Application by Ecotricity (Heck Fen Solar) Limited  
Heckington Fen Solar Park

## **The Examining Authority's written questions and requests for information (ExQ1) Issued on 17 October 2023**

DRAWING NUMBER: P20-2370\_107

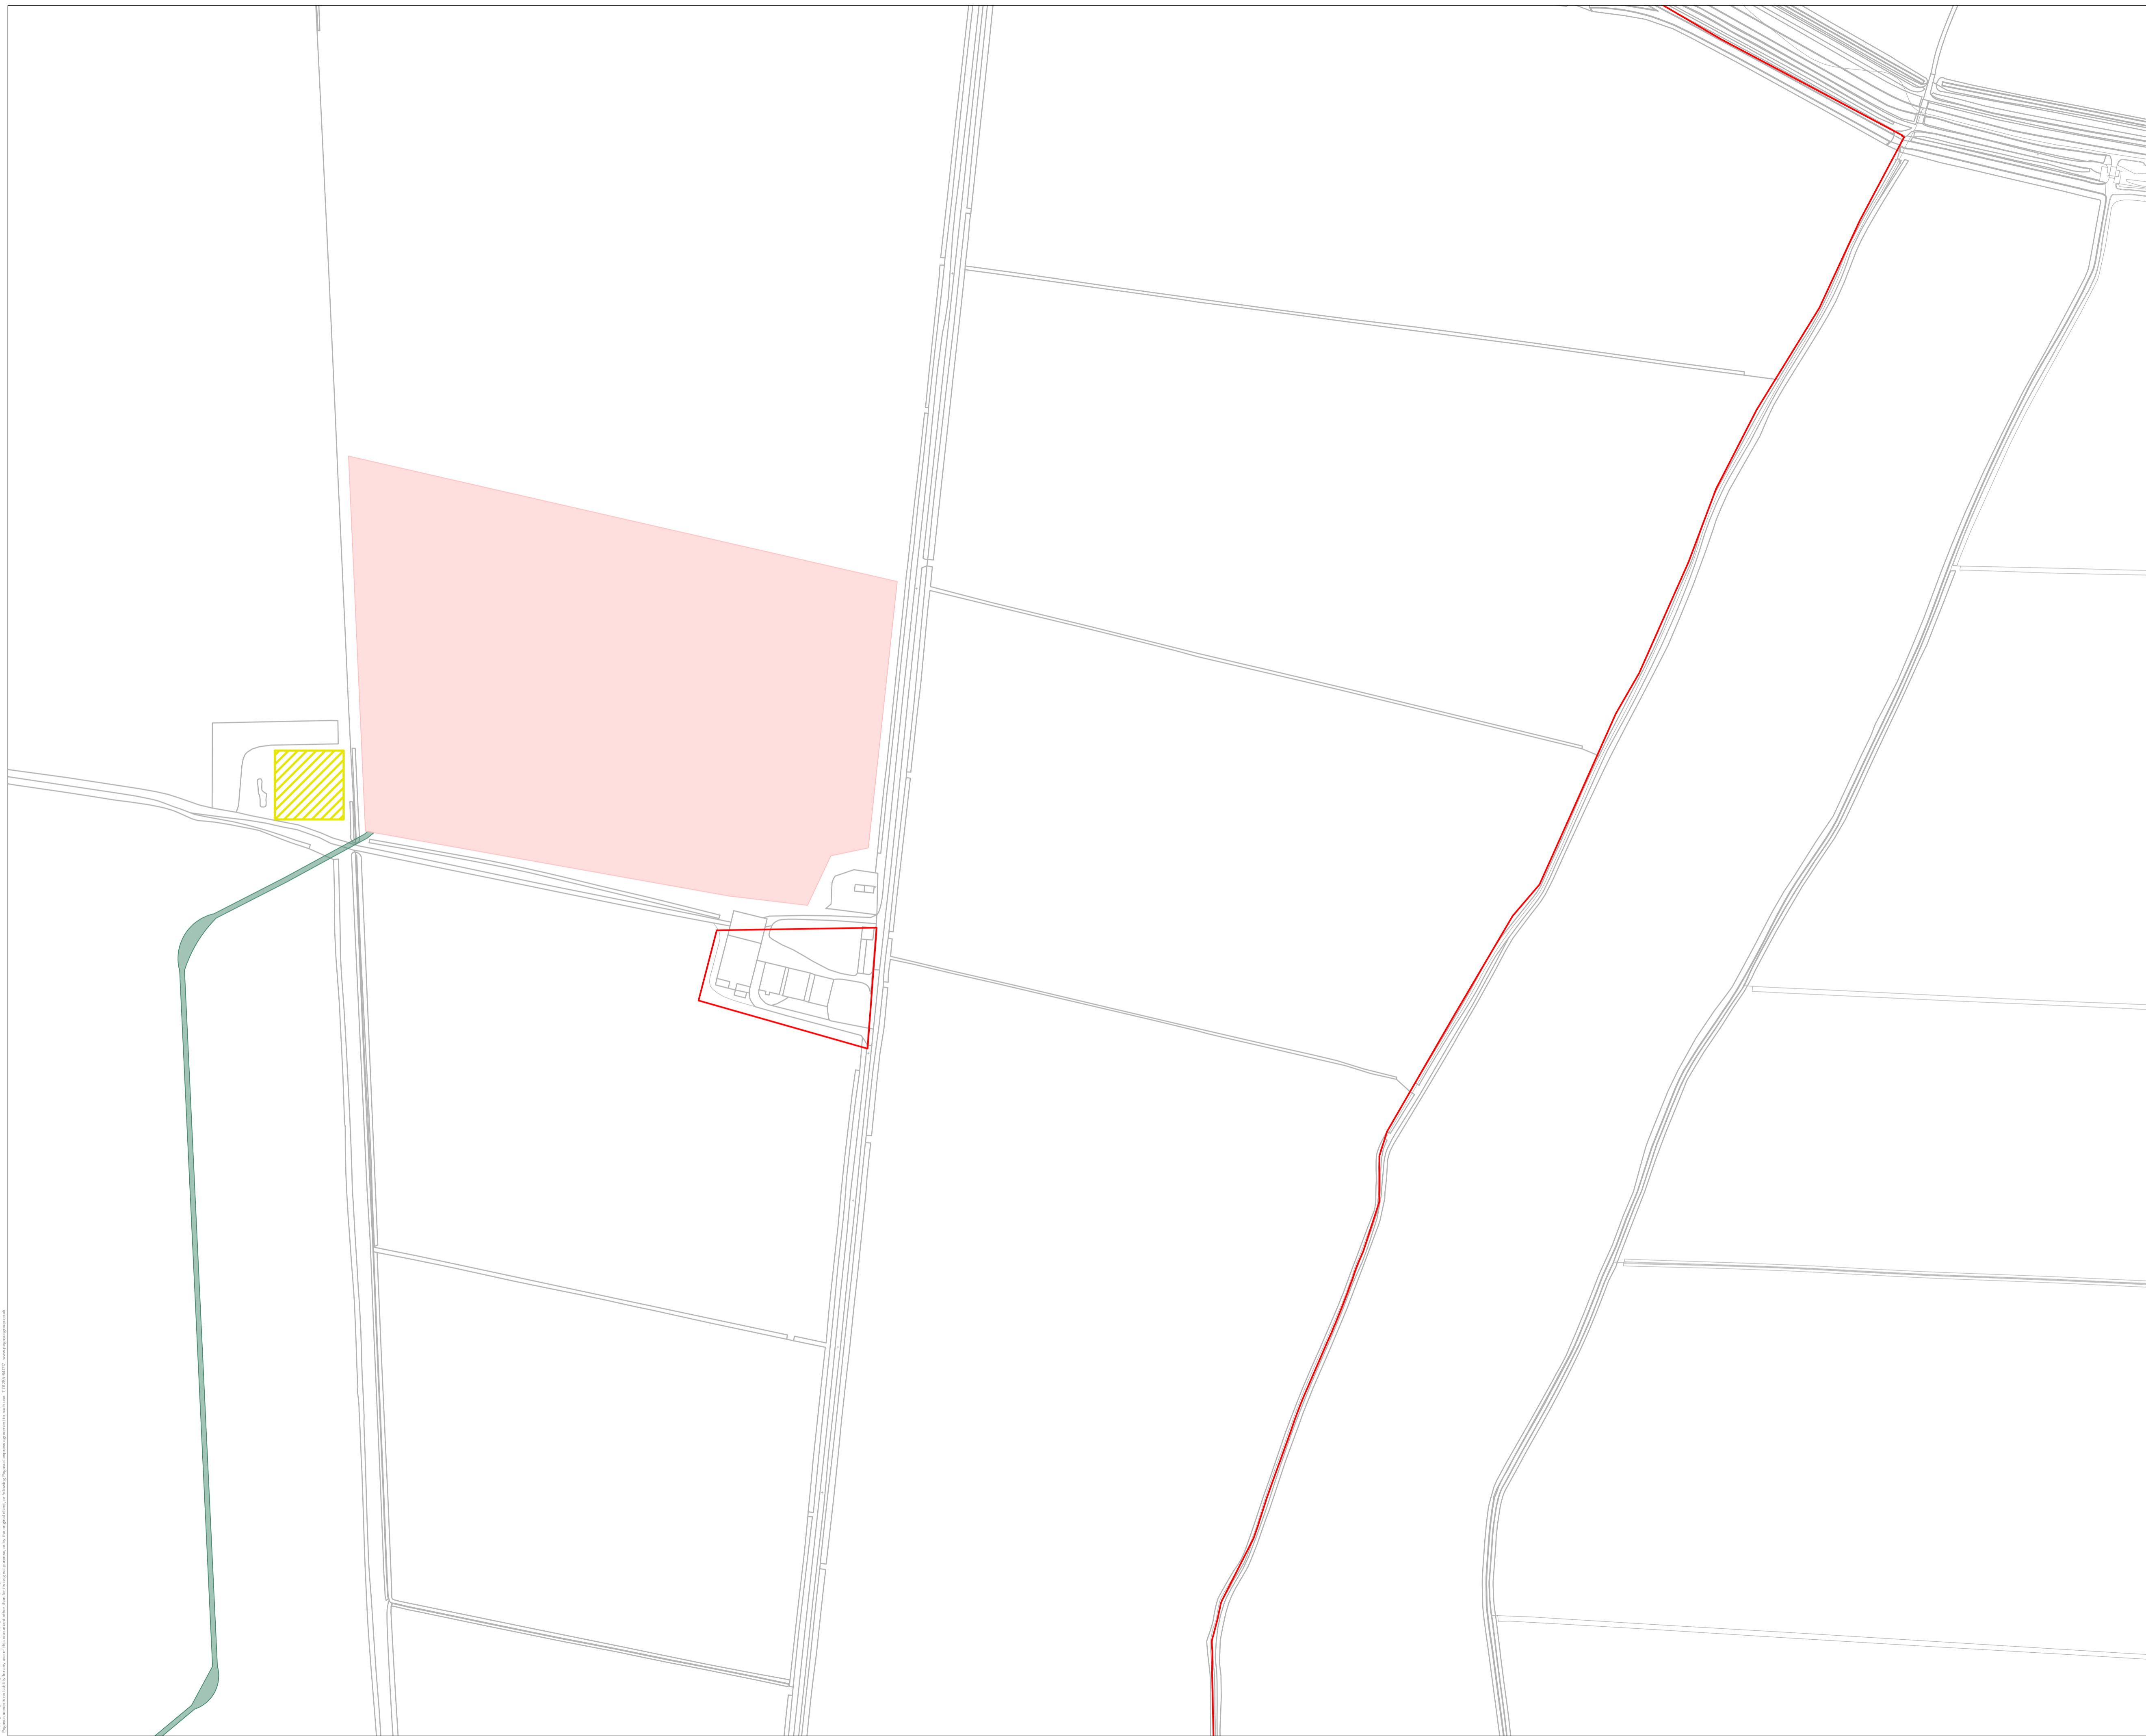
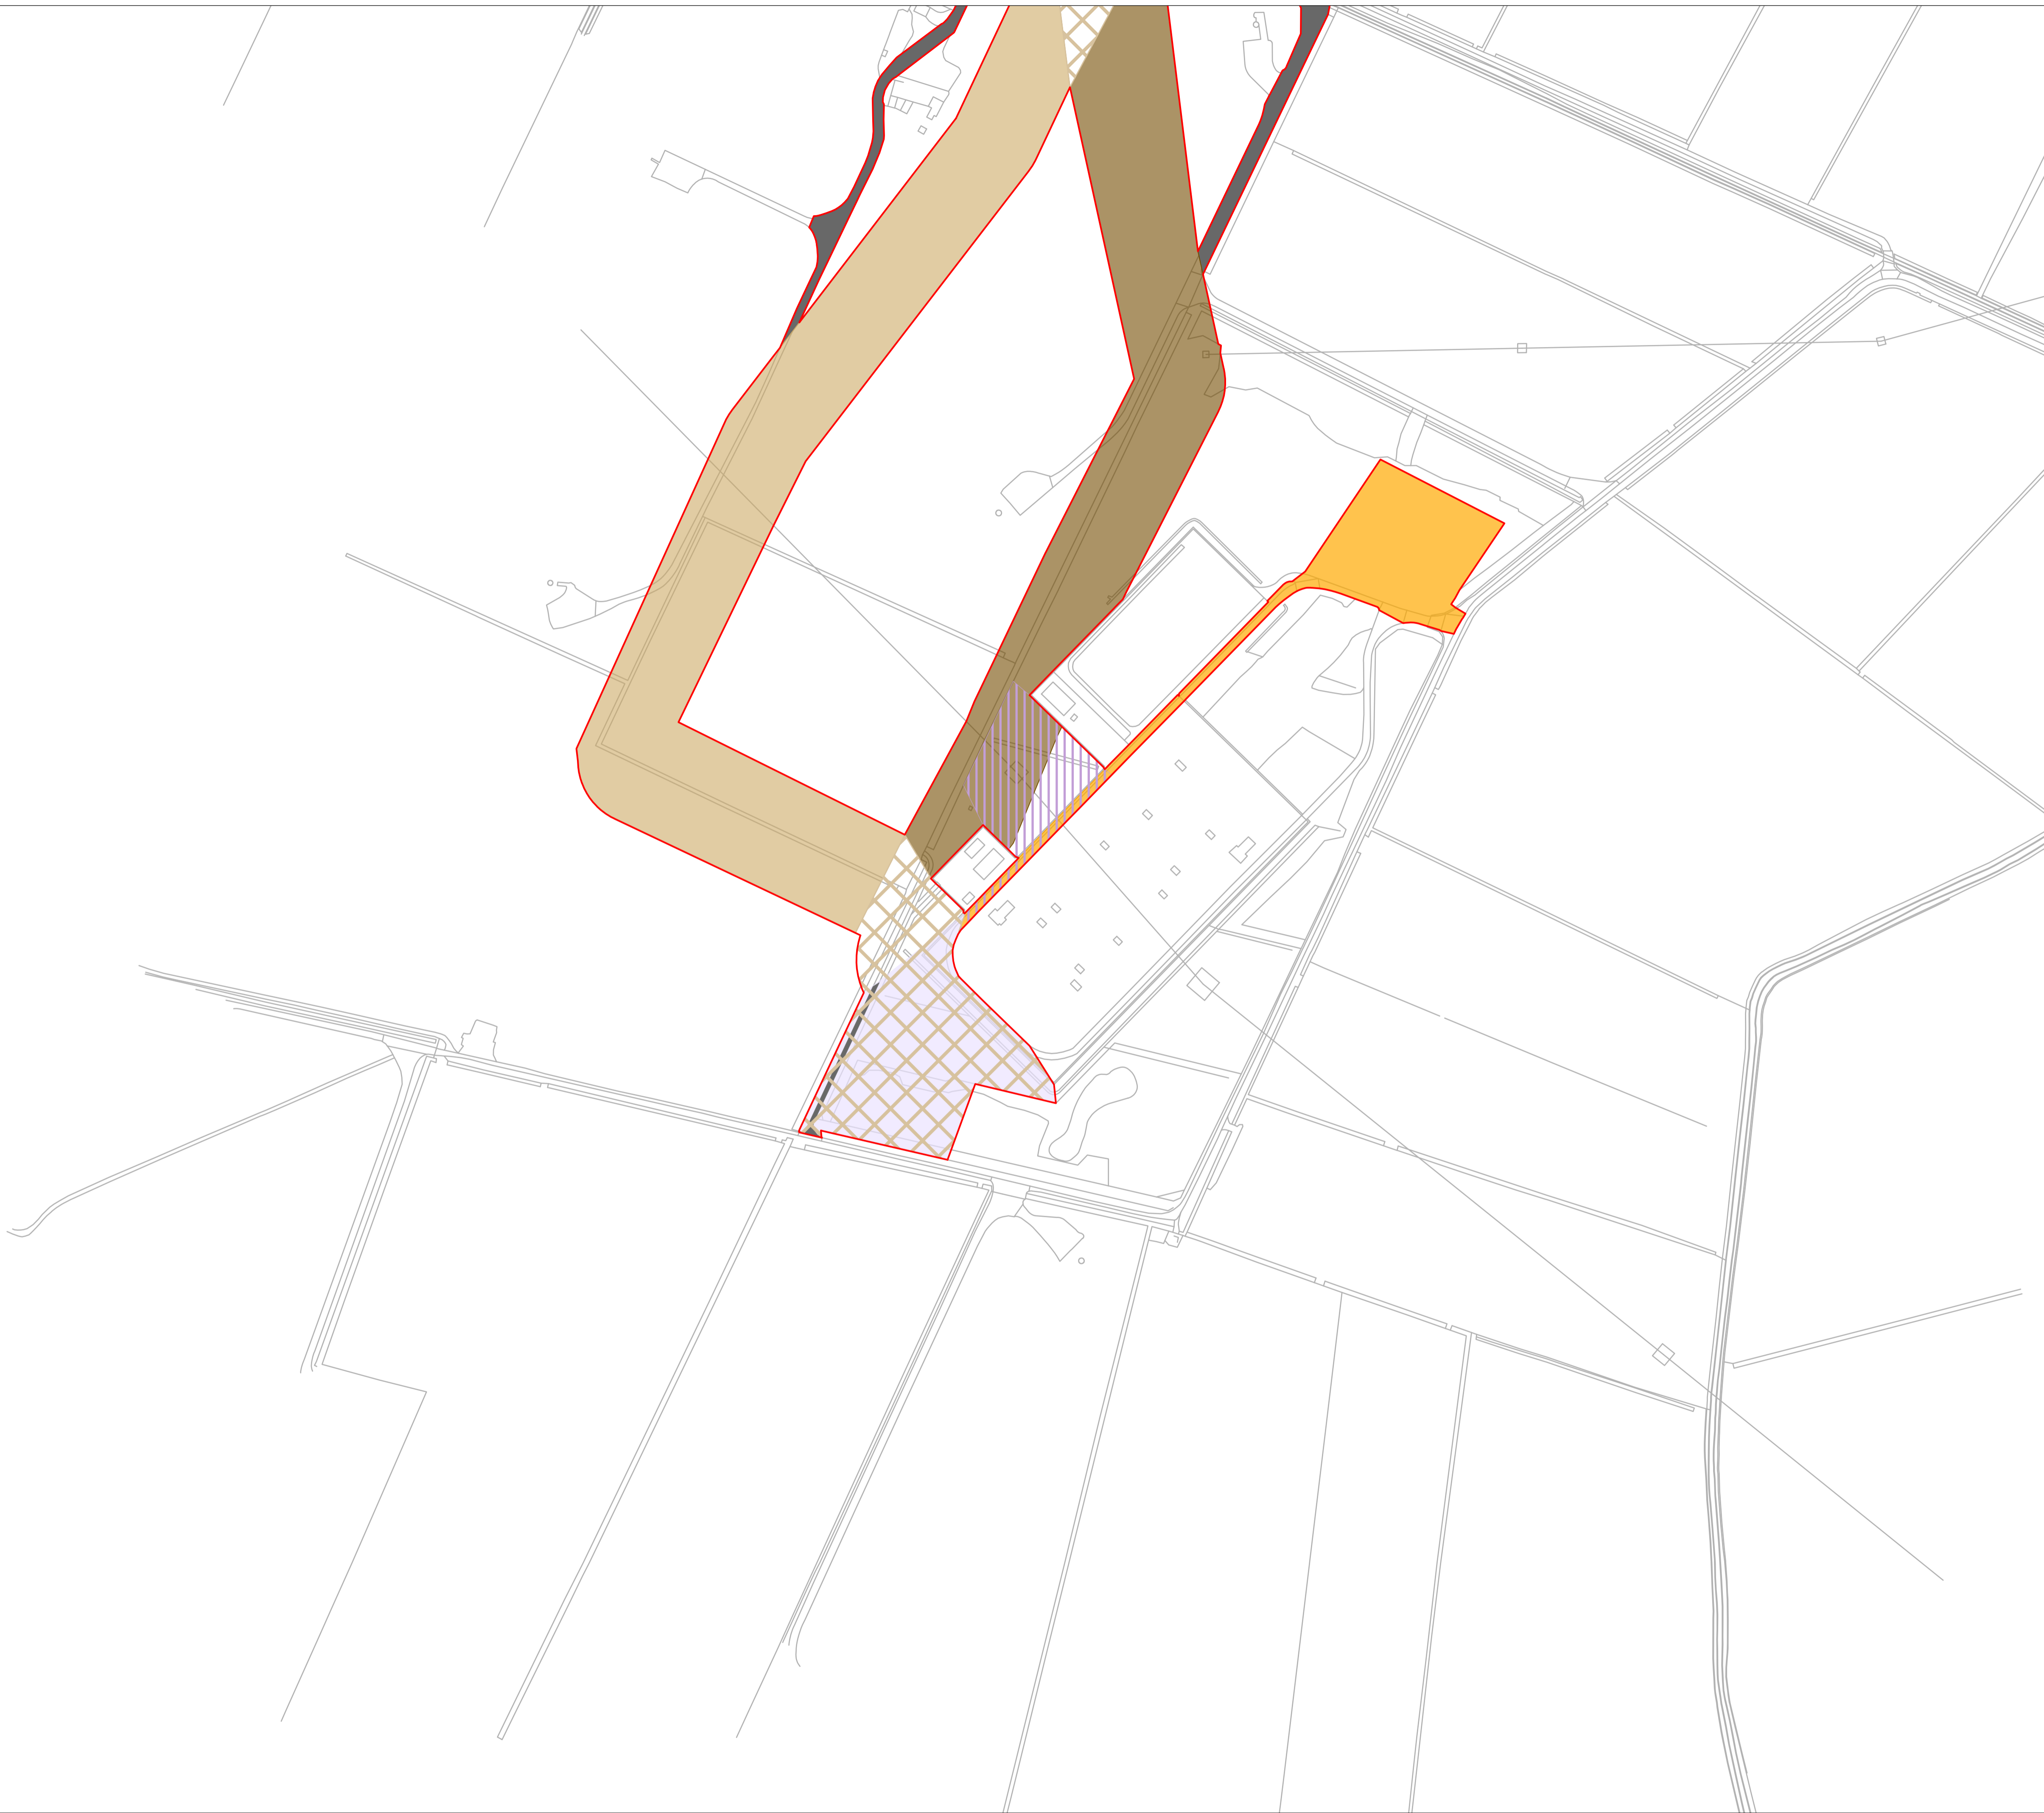
<b>ExQ1</b>	<b>Question to:</b>	<b>Question:</b>
<b>1. GENERAL, MISCELLANEOUS AND CROSS-TOPIC QUESTIONS</b>		
GEN.1.1	Applicant	<p>Sheets 5, 6, 12 and 13 of the Works Plans [PS-014] show numerous overlapping Works No's around the on-site substation and the Bicker Fen substation. Due to the scale of the plans and the overlapping colours/patterns the exact boundaries of many of the Work No's in these areas of the Proposed Development are ambiguous.</p> <p>Provide individual plans to clearly show the extent of each of the Work No's in these areas. These should not supersede the Works Plans but would be supplementary to them.</p>
GEN.1.2	Applicant	<p>Paragraph 3.4.1 of Environmental Statement (ES) Chapter 3 [PS-053] states that the layout of the Proposed Development has evolved taking into account "<i>planning and environmental policy objectives</i>".</p> <p>Could the Applicant provide further detail for each of the relevant "<i>environmental policy objectives</i>" and design objectives set out within the Statement of Need and Planning Statement [PS-142], and how these have been taken into account within the iterative design process described within the ES.</p>
